Recommendation Report for Planning Permission for Works or Extension to a Dwelling

REF NO: BE/143/20/HH

LOCATION: Anderson Cottage
Shripney Road
Bognor Regis
PO22 9PA

PROPOSAL: Removal of existing conservatory & erection of pitched roof single storey rear extension

Drg No: 1676/20/P/03

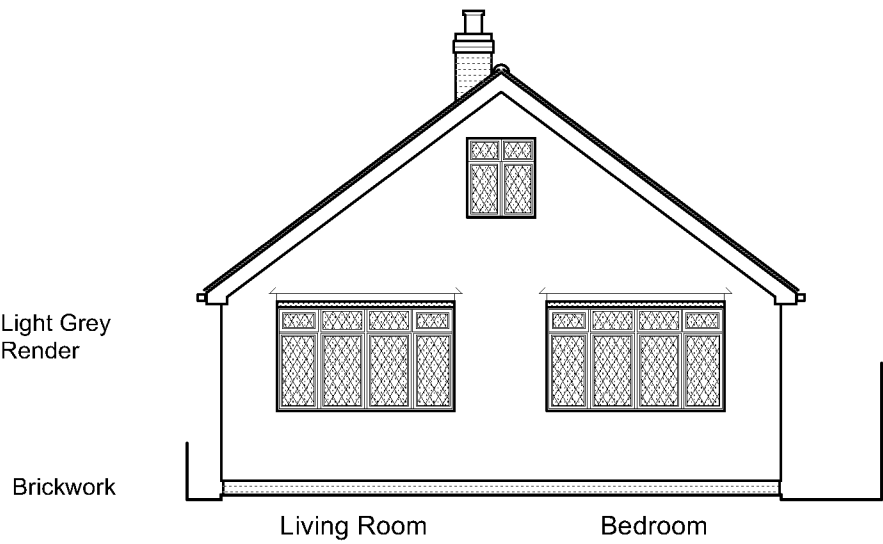
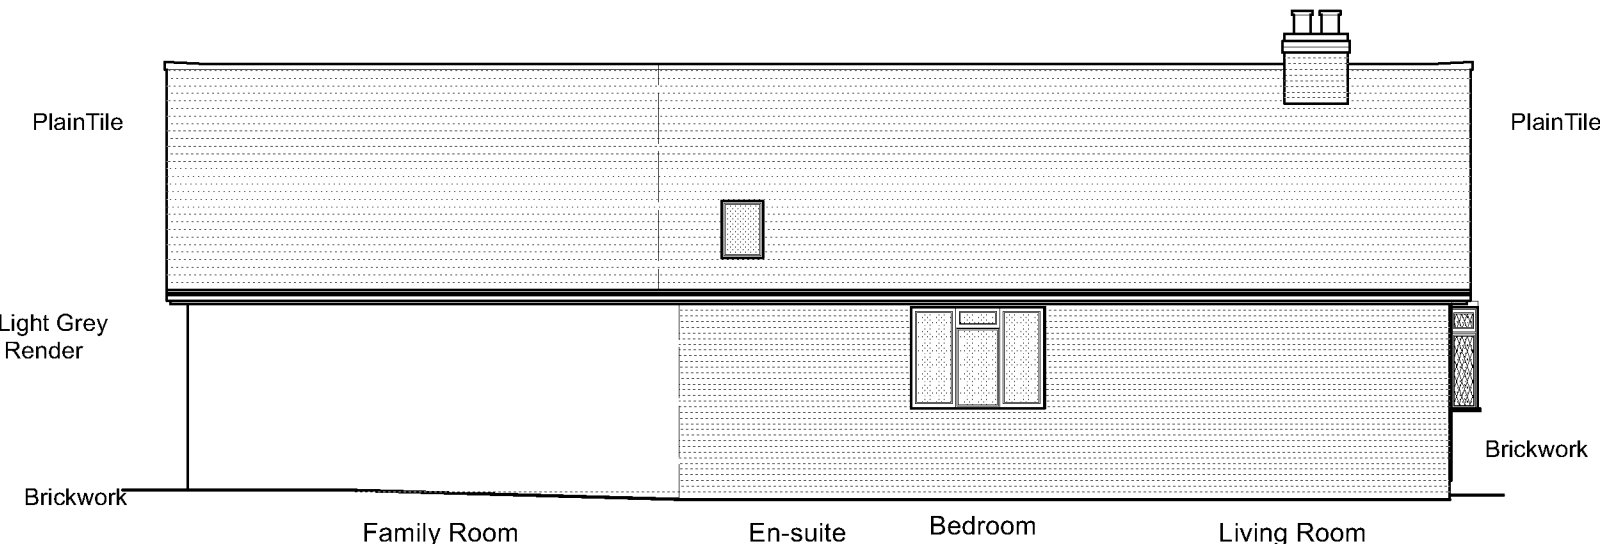
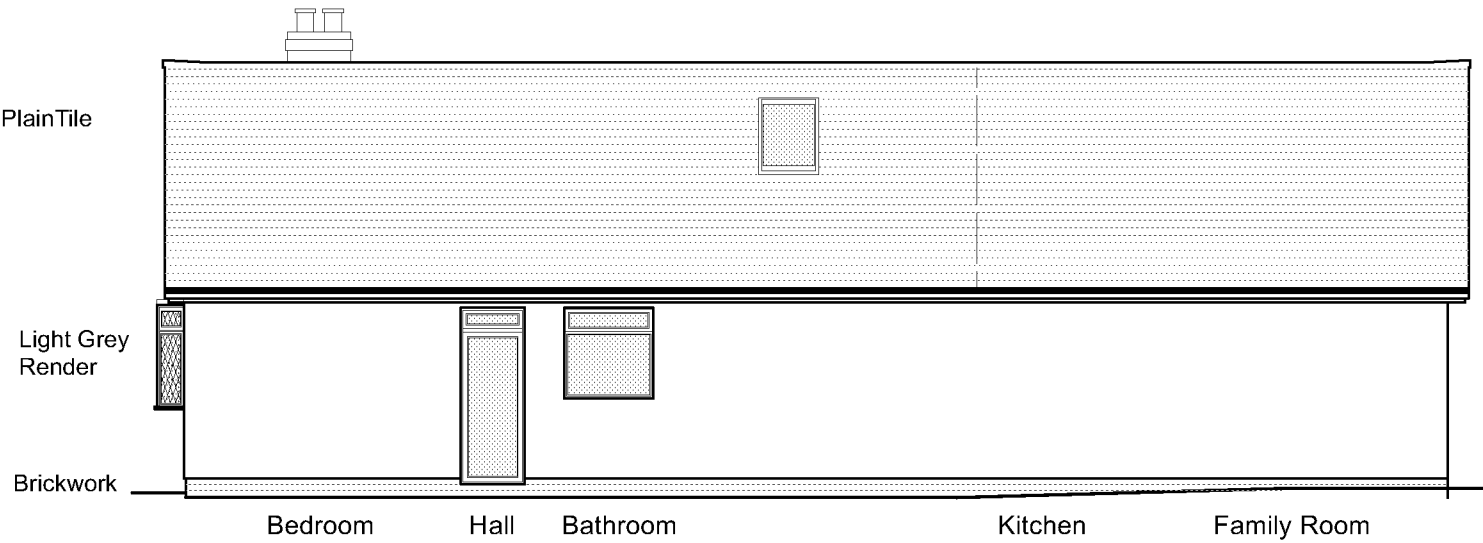
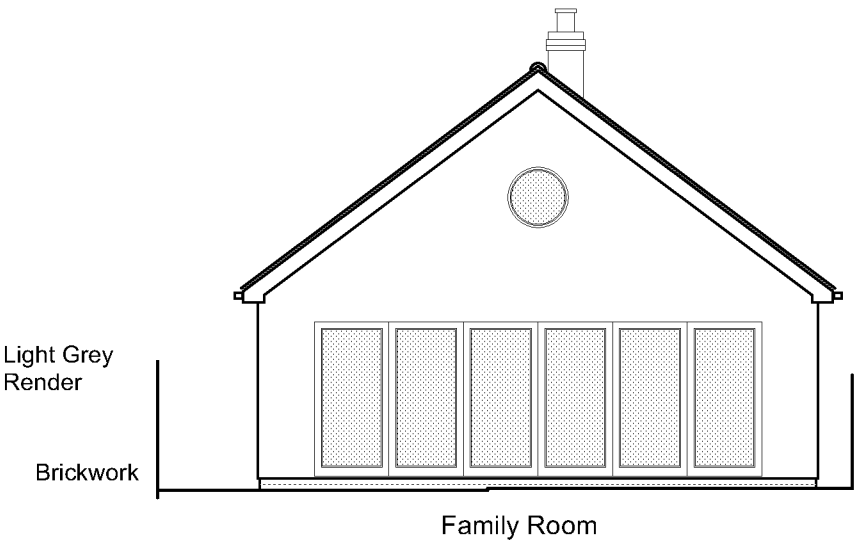
The proposed extension is to project in alignment with the rear elevation of the building by 6.5m in depth and extend across the dwelling's entire width and be built of material to match the existing. Its roof is to be a continuation of the existing roof plains and the eaves line will match the exiting dwelling. The proposed fenestration is thought to be of a suitable scale and sit comfortable against the existing although it is noted that there has been a departure from the leaded lights, this is not thought to be detrimental to the application. The extension will not be visible from the street scene and it is therefore believed that the scale and style of the extension will sit harmoniously alongside the existing dwelling and as such will accord with D DM1 and D DM4 of Arun's Local Plan.

It is proposed that the extension will project from the entire width of the rear portion of the bungalow, maintaining the current eaves height of approximately 2.5m from the boundary. The bungalow itself sits in a modest plot that is comparable to others in the locality. It is not proposed that it will encroach any closer to its relevant boundaries, maintaining 1.2m to the Southern boundary and a little over 600mm from the Northern. A continuous ridgeline has been proposed which is believed to tie the extension to the existing house well. There is no fenestration to side elevations which could lead to a feeling of perceived overlooking, with all proposed fenestration to face into private amenity space. Therefore, it is not felt that the proposed extension will be overbearing or overshadow its neighbours and accord with policies DDM1 and DDM4 of Arun's Local Plan.
